Our reference: ECM: 9326999 & 9325201
Contact: Gavin Cherry
Telephone: 02 4732 8125

20 October 2020

Response to Request for Comments on SEARs Proposal for the Oakdale West Estate - Modification 6 (SSD-7348 MOD-6) & Separate SEARs Proposal for Stage 3 Development of the Oakdale West Estate at 2 Aldington Road, Kemps Creek

Figure 3-6 Proposed Masterplan

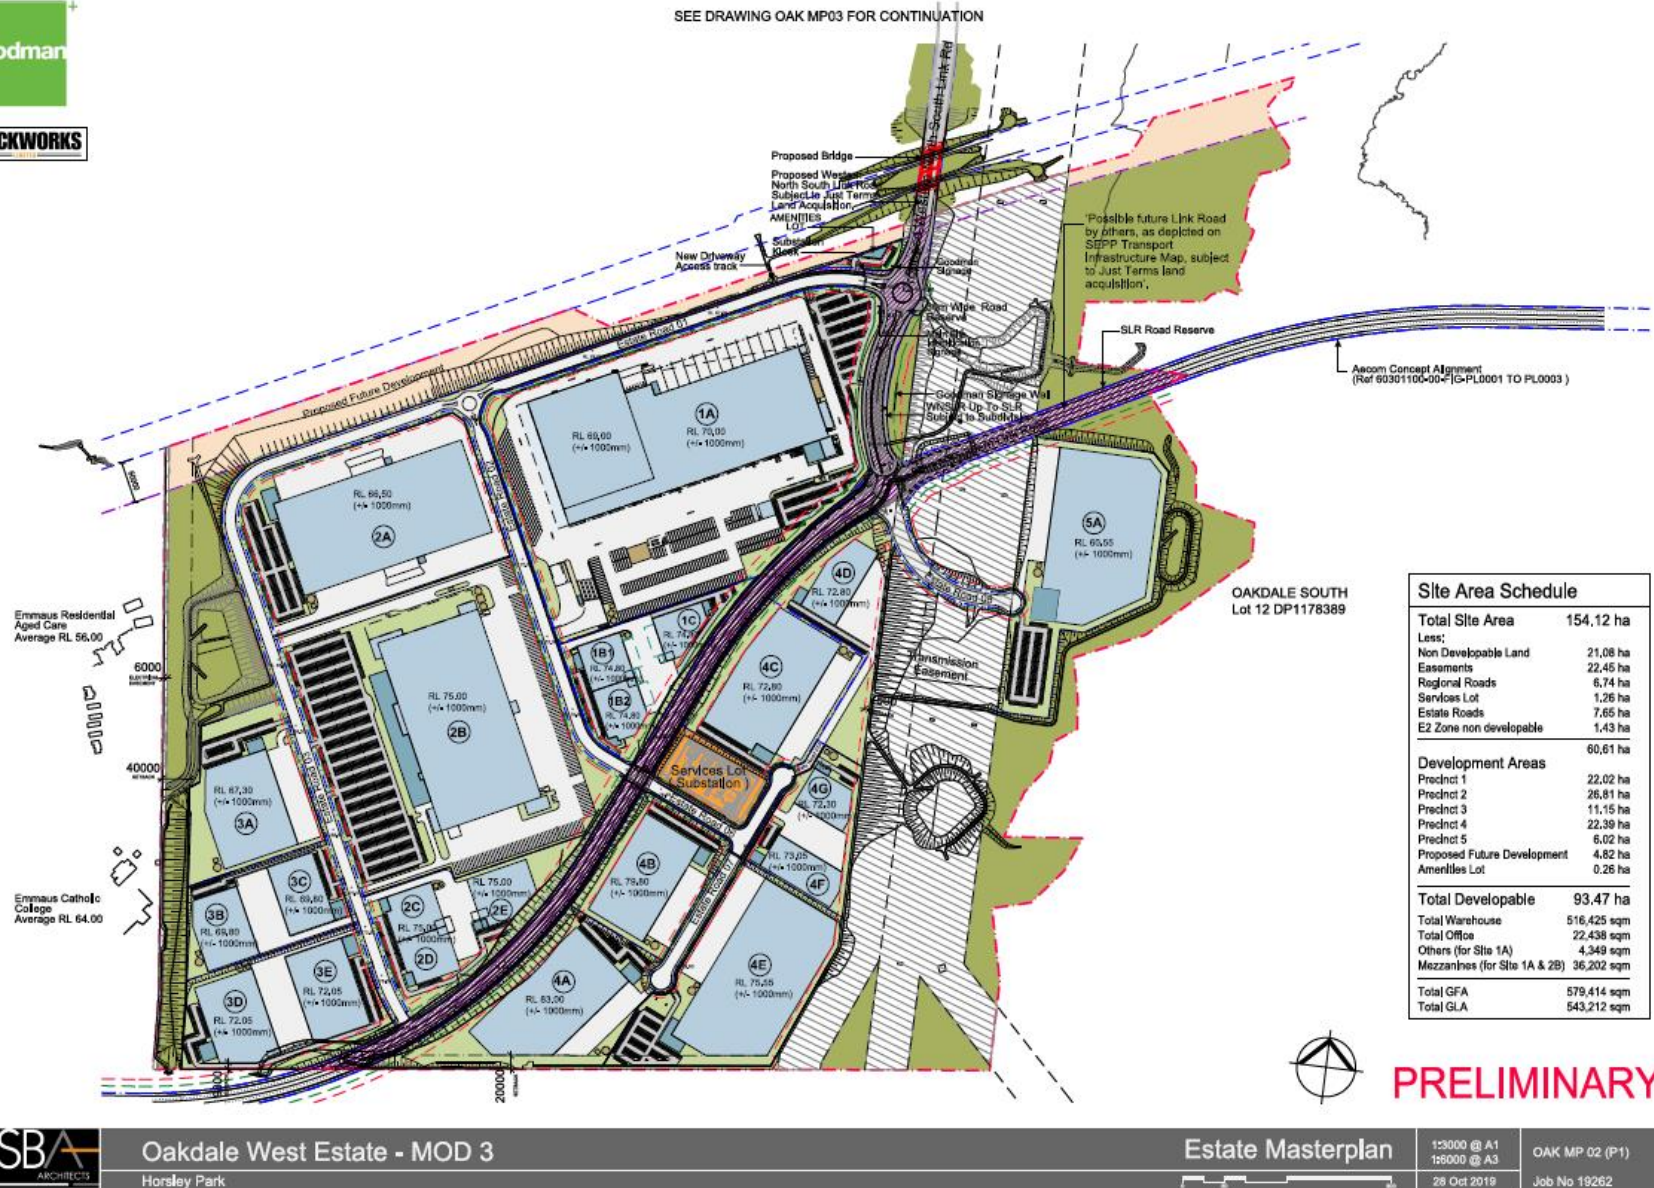
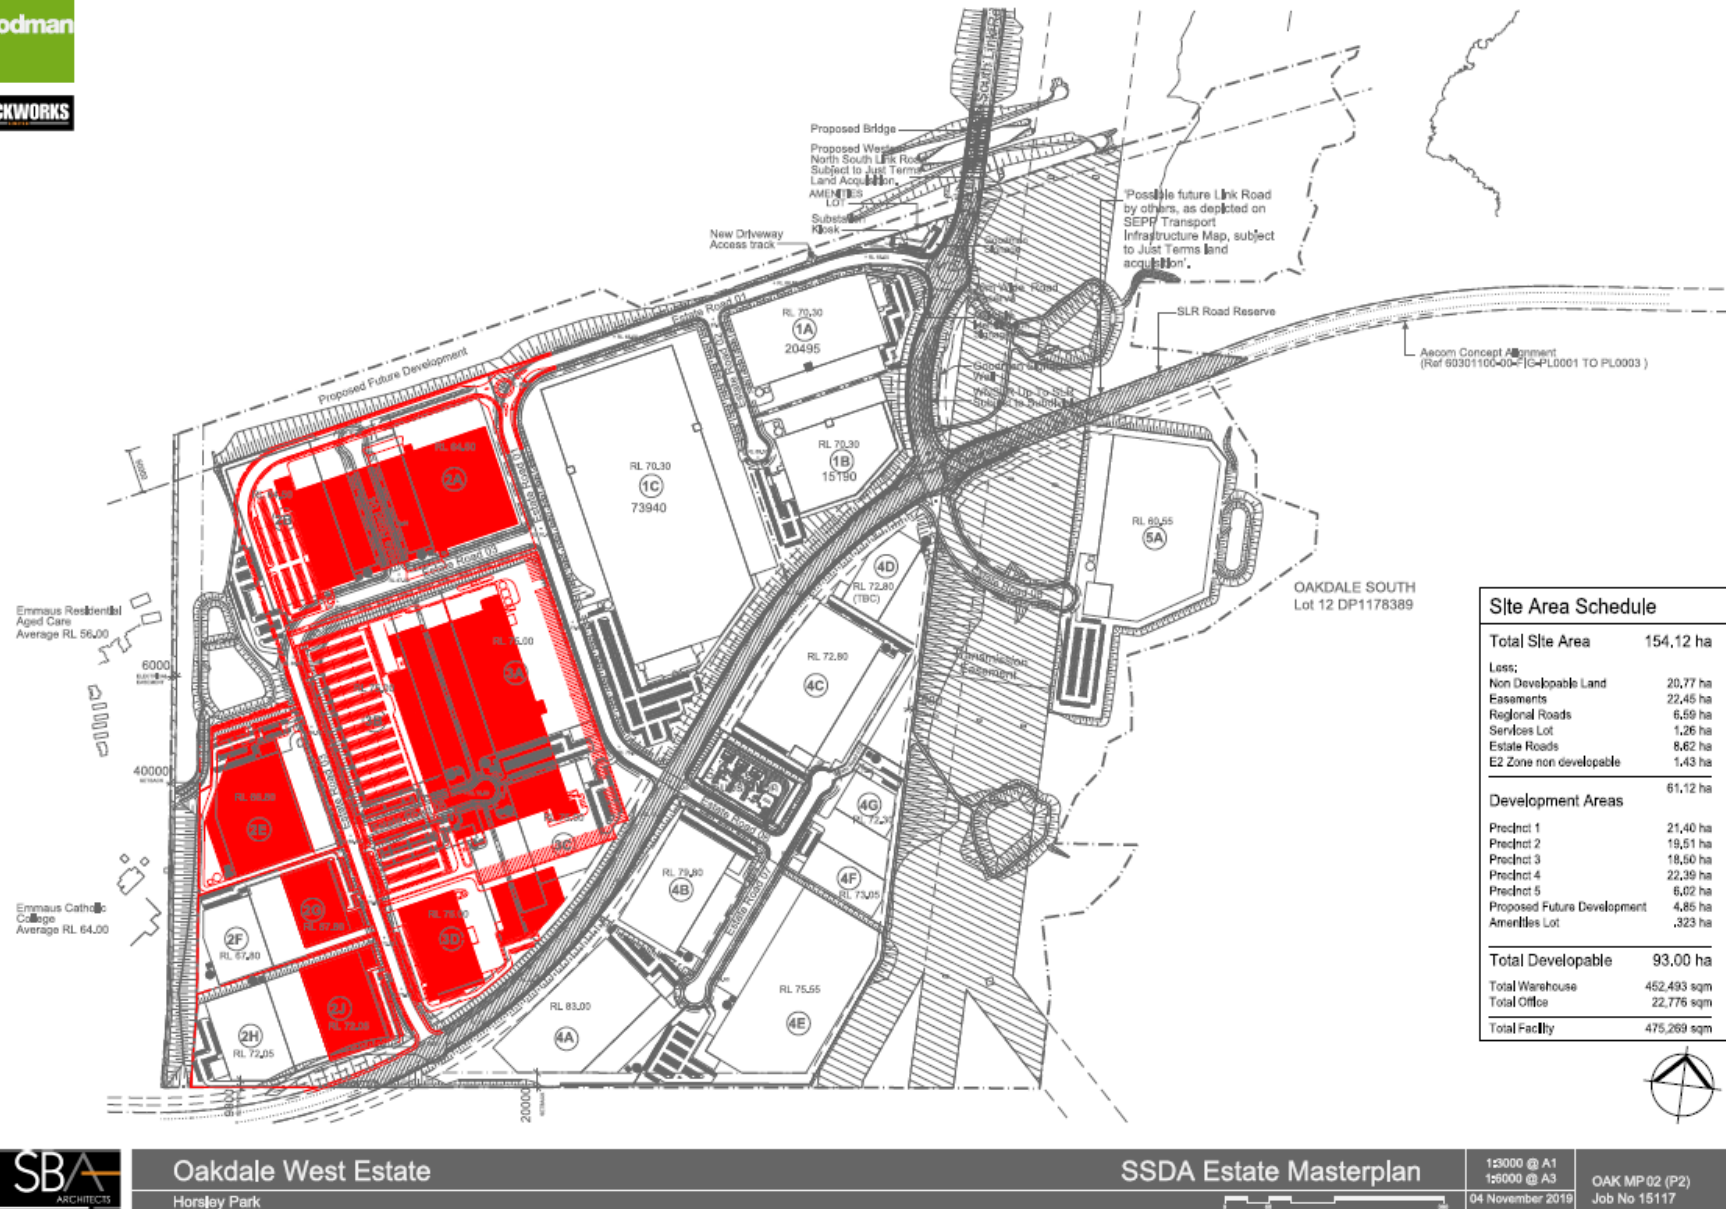
The submitted Request for Sear's Report did not appear to provide a comparative diagram of the approved scheme in contrast and for comparison to, the proposed amended scheme. The EIS that is submitted with Modification 6 should ensure that an illustrative representation of the approved scheme is depicted in combination with the proposed scheme for comparison in the assessment process.

The proposed spatial arrangement of Lot 2A and the relocation of car parking from Estate Road 1 (north – south) to Estate Road 1 (east – west) raised no specific concerns provided the landscape setbacks secured within previous Modifications to the overarching concept plan are substantially reflected within this revised proposed. The majority of the car park in the setback for Lot 2A achieves a 7.5m setback to the front property boundary however some motorcycle parking encroaches at the western and eastern ends. While the encroachments are minor, opportunities to maintain an unimpeded 7.5m landscape setback for the entire boundary is requested, especially as the corners of the site end up being the most visually prominent on the approaches.

The car park and landscaped setback for Lots 2C and 2D, south of the Stage 2 development works are inadequate and undermines the streetscape outcomes secured through the Stage 2 Development works to the north. A front setback of 6.0m to 7.5m was established for the landscaped zone of the Amazon

Development and this setback must be continued for the full length of the block / Estate Road presentation. The suggestion of a significantly lesser setback for Lost 2C & 2D undermines the streetscape outcomes that were fundamental to the support of Stage 2, and sets up an irregular streetscape presentation between the developments. The plans in support of the SEAR's request also appear to reflect an incorrect setback line for the Amazon Development front car park, which needs to be checked and rectified if this is an error.

The car park configuration encroaching forward of the established setback pattern in the street requires amendment and may necessitate a reduction to gross floor or allotment yield if it cannot be otherwise made compliant.
